RE: 2440 Louisiana Office Bldg
Conceptual Grading & Drainage Plan
Engineer's Stamp Date: 01/17/22
Hydrology File: H19D084

Based upon the information provided in your submittal received 01/21/2022, the Conceptual Grading & Drainage Plan **is not** approved for action by the DRB on Site Plan for Building Permit. The following comments need to be addressed for approval of the above referenced project:

C101

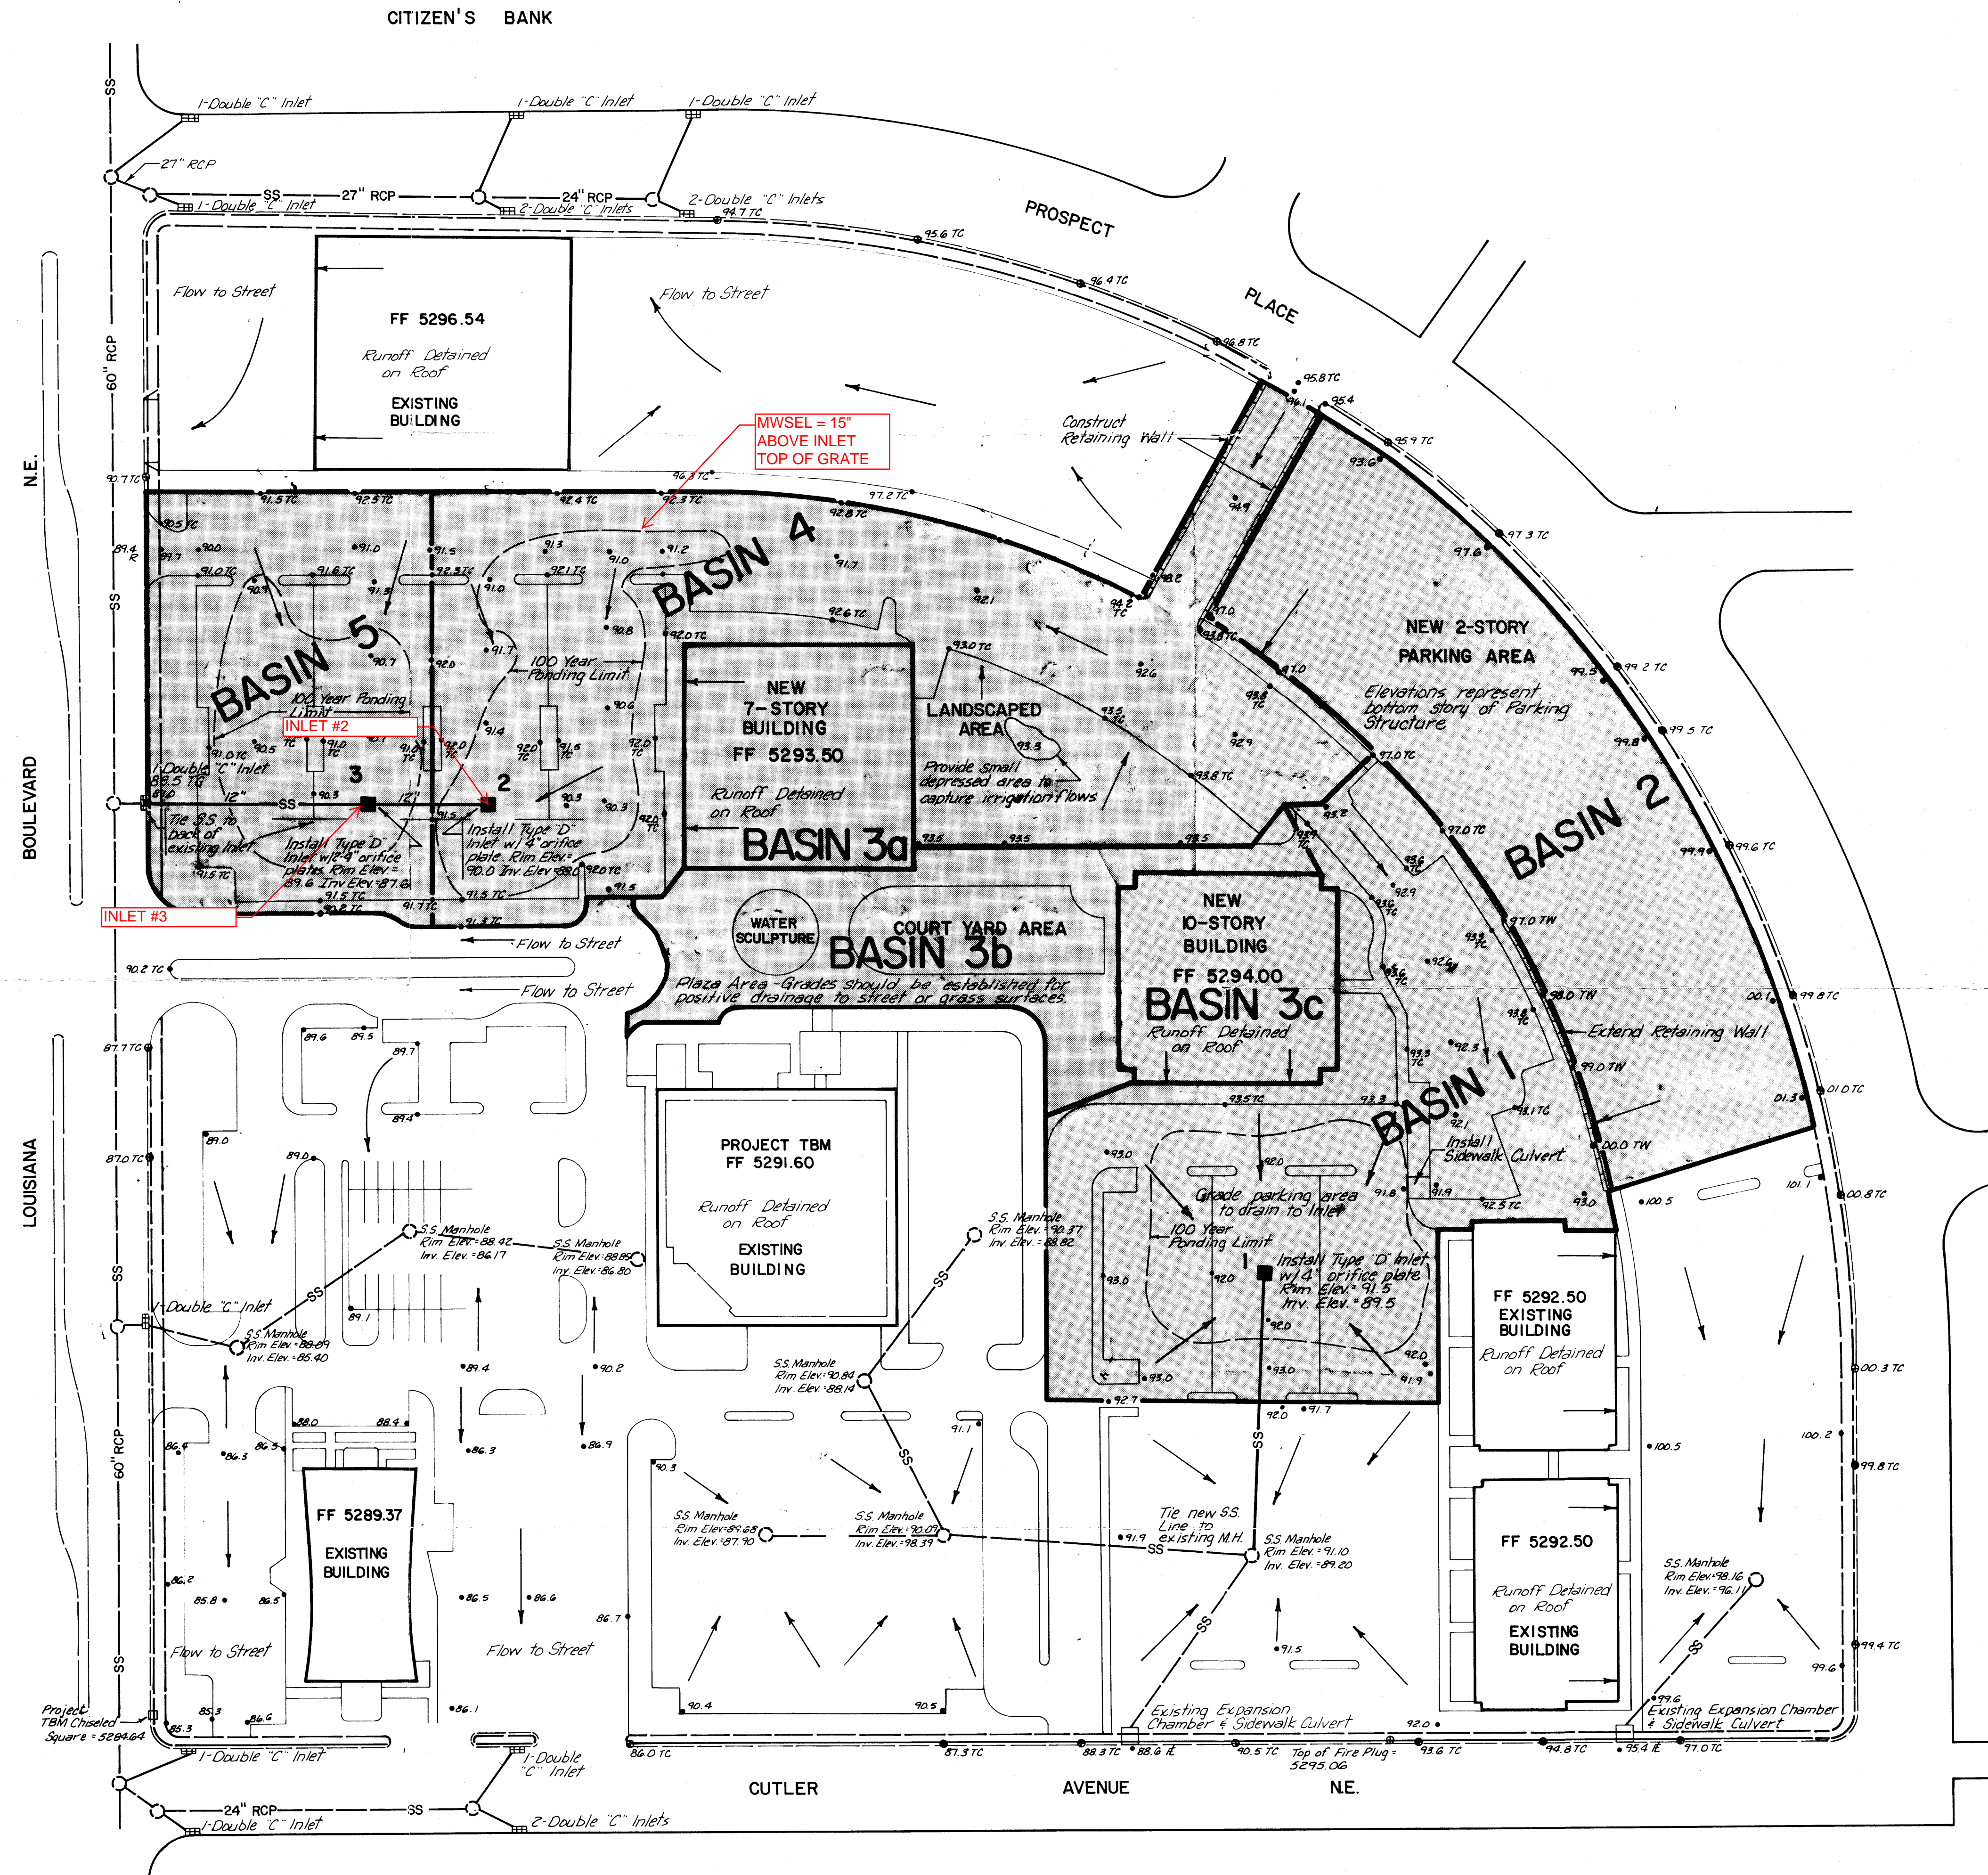
1. Under Existing Conditions, reference to prior drainage file H16-D1 is inaccurate. The actual drainage file is H19D084. According to this drainage plan, this site has limited discharge. See attached plan and calculations.
2. Below is an image of the existing parking with two ponding area utilizing the parking and adding about 15 inches above the inlets to store the detention volume.

Since it looks like a large portion of detention basin #5 is being removed, an underground system will have to be utilized and outfall to the existing inlet on Louisiana. Also, since Basin #4 ties into Basin #5, Basin #4 will also have to be re-evaluated to determine that it can still provide the required detention.
